JPT/CH-AS/7108

10th August 2015

Re: 31 Sea Way Middleton on Sea PO22 7RZ – M/56/15/HH

Proposed Floor Plans
- Ground Floor
- First Floor
- Roof Plan

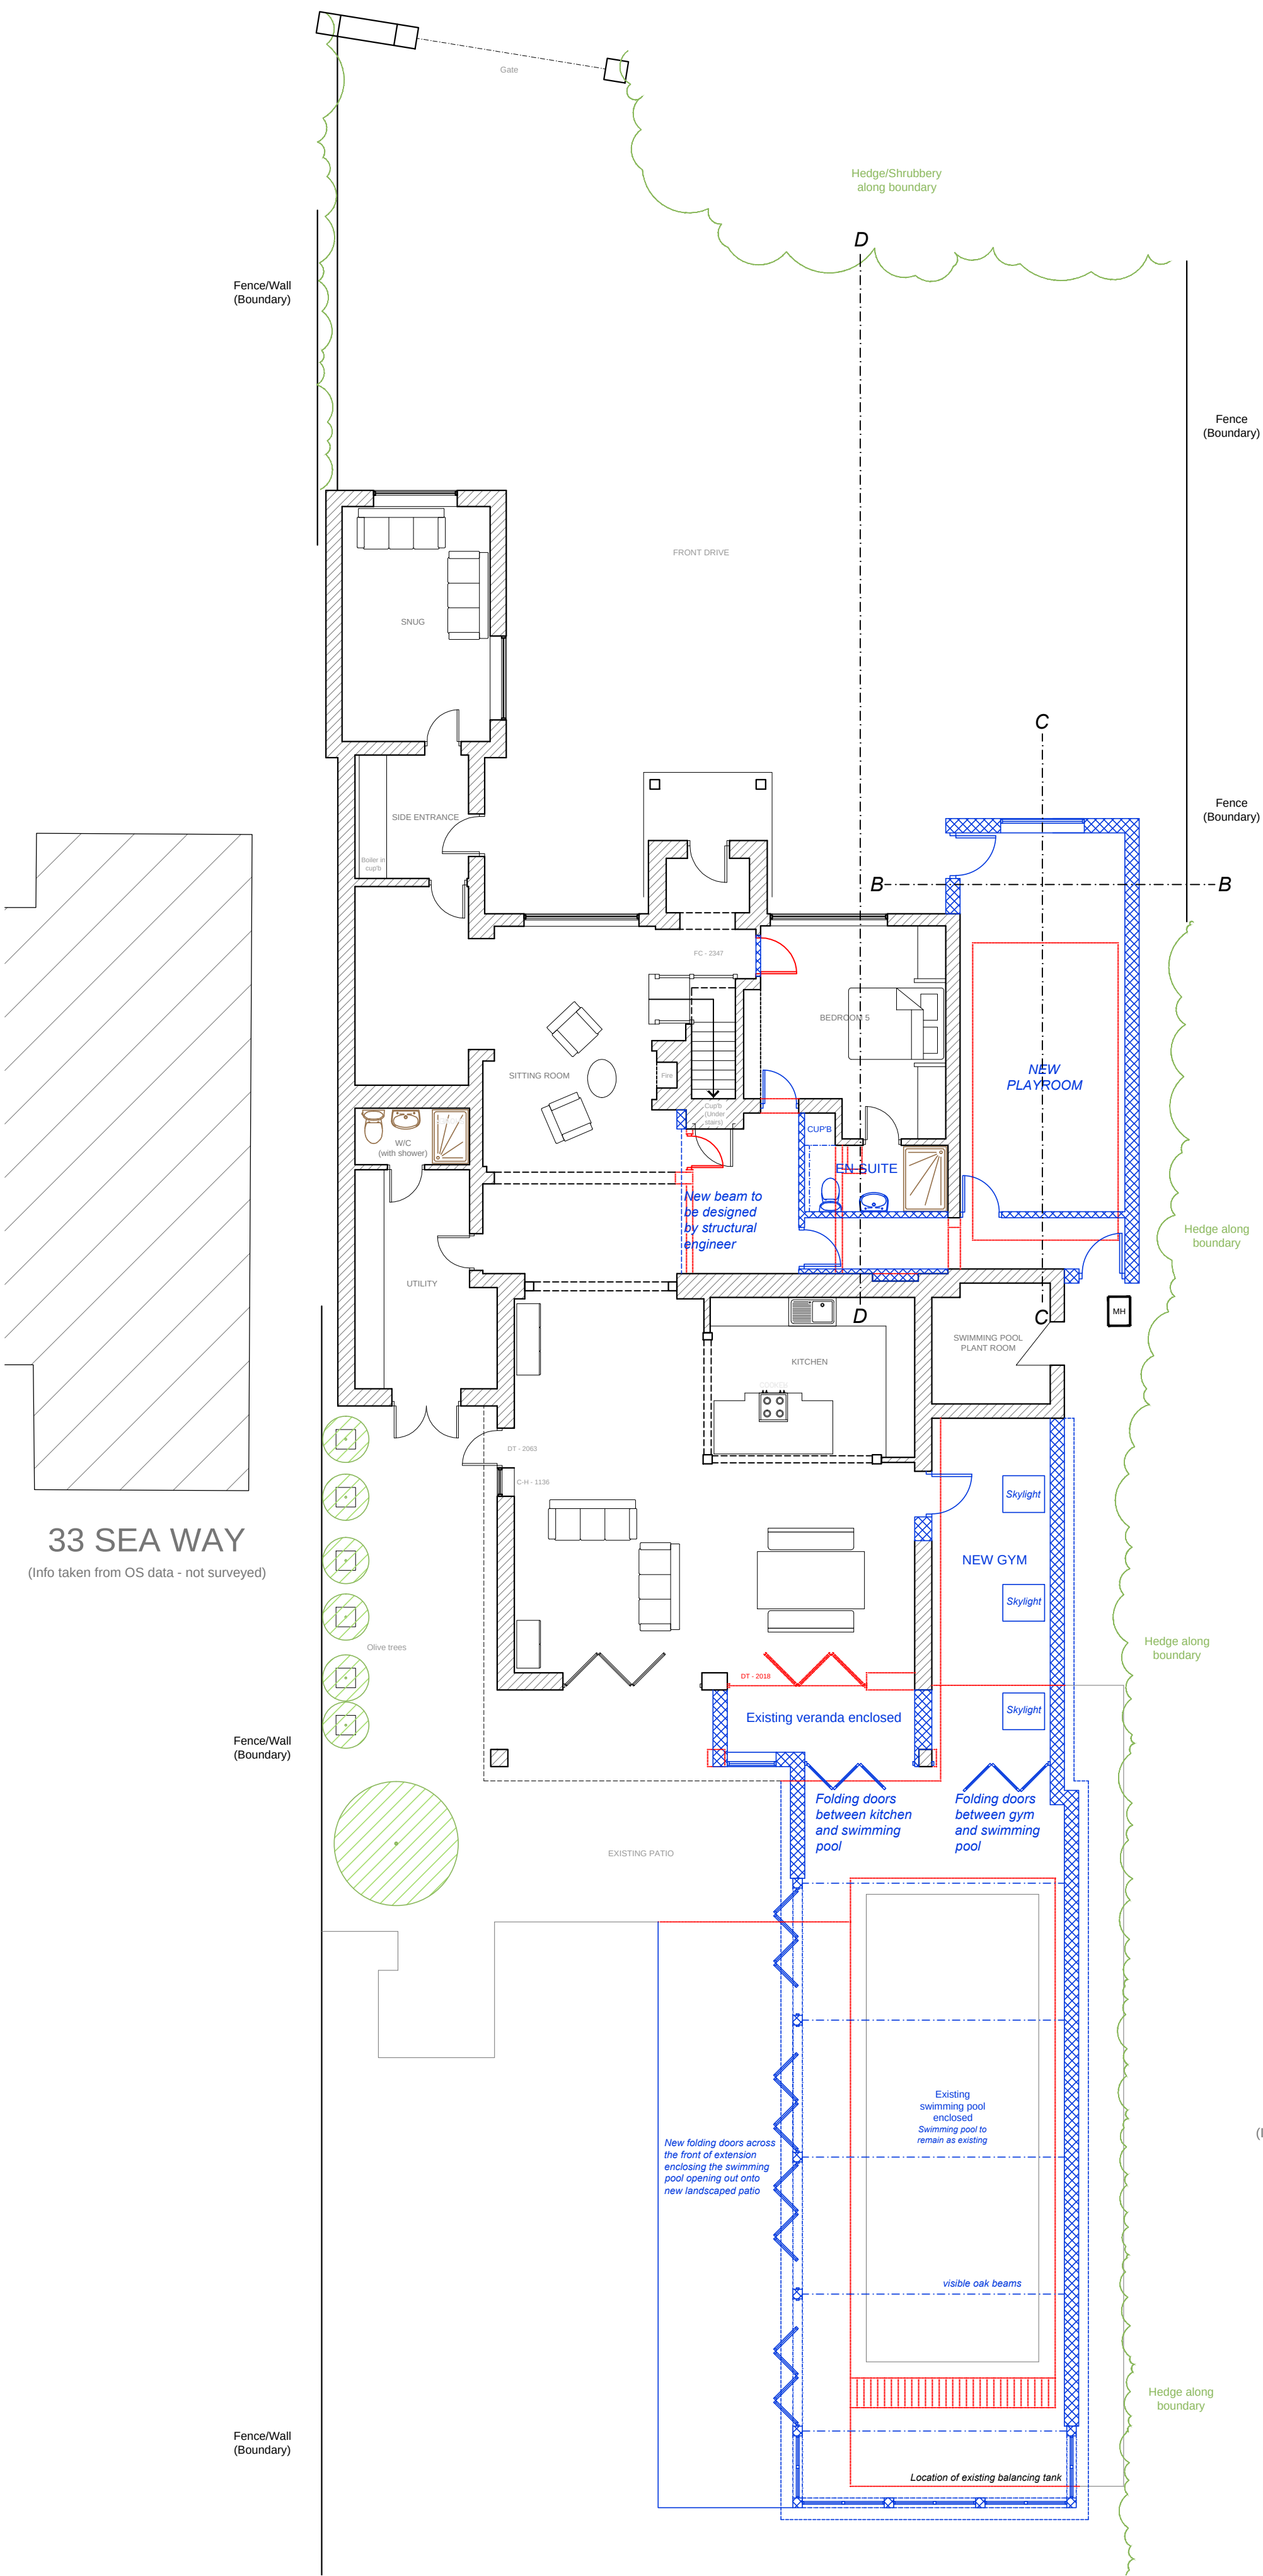
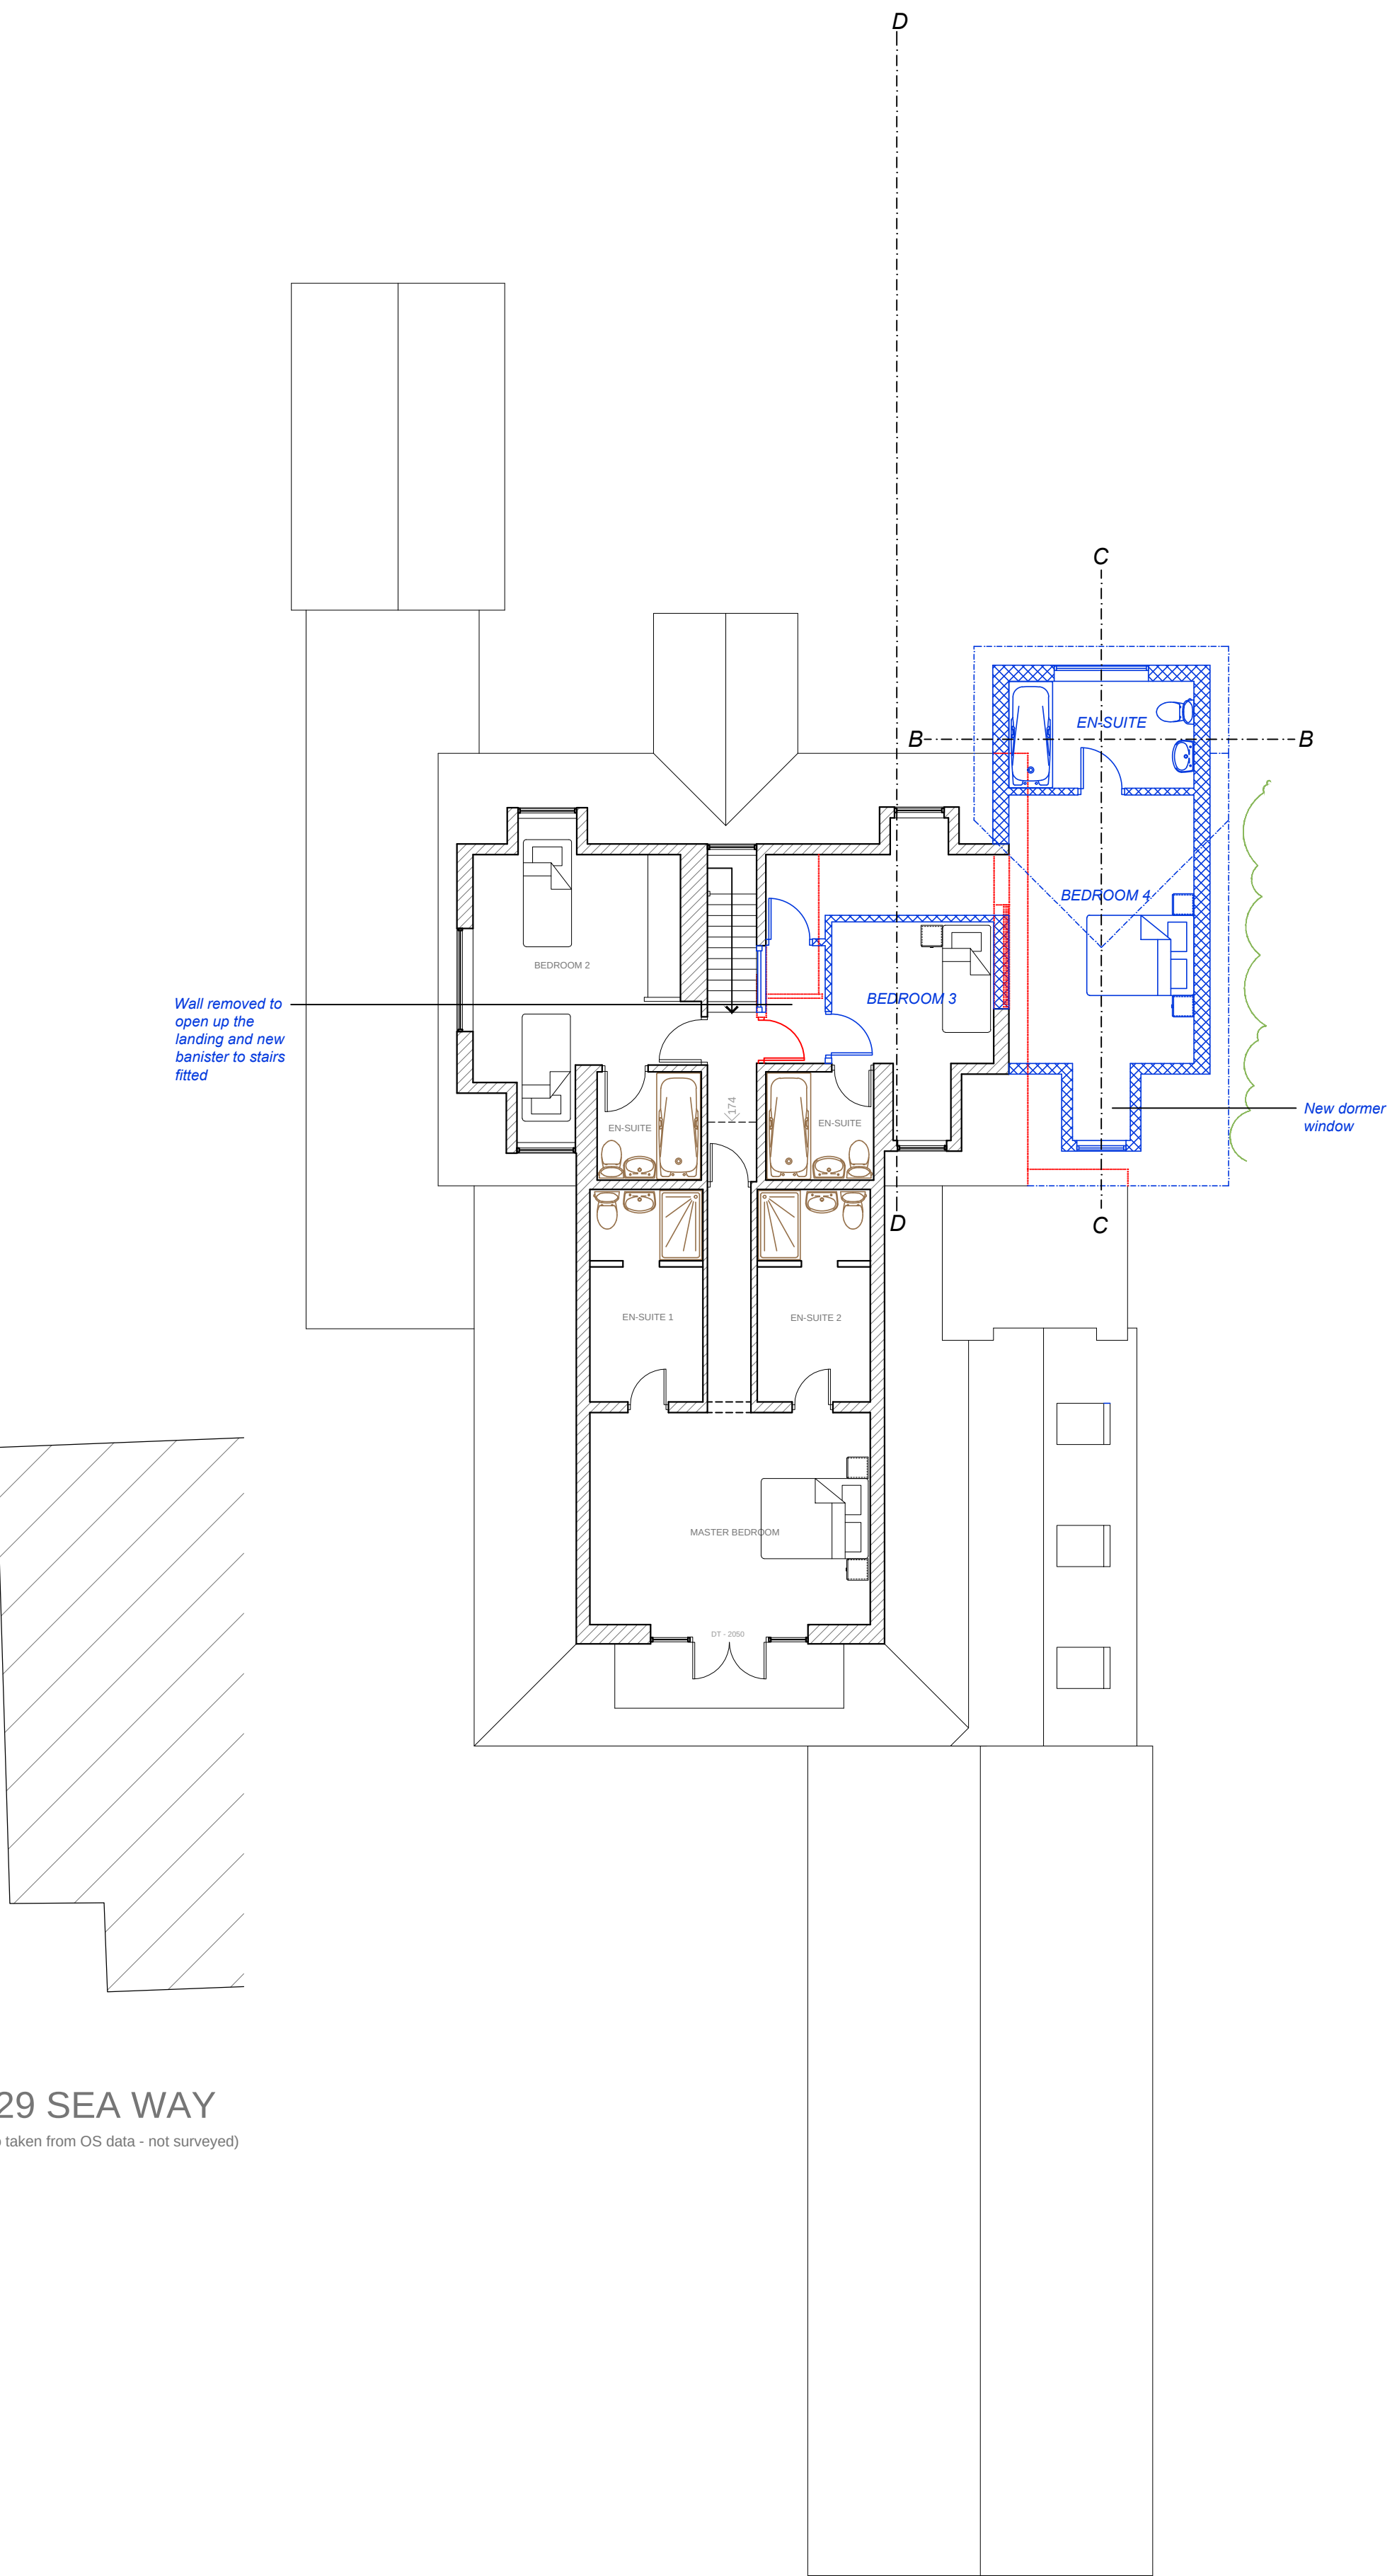
1. The East boundary on the block plan is virtually a straight line. The boundary line on the substitution of 6th July 2015 in relation to the floor plan does not show a straight line, nor is it clearly defined. The distance between the boundary and the proposal therefore varies.
2. As the question of the extension is in relation to the boundary, this should be defined in relation to the Title documents or the Land Registry documents.
3. There is reference to the East boundary in the application but no indication of ownership or liability.
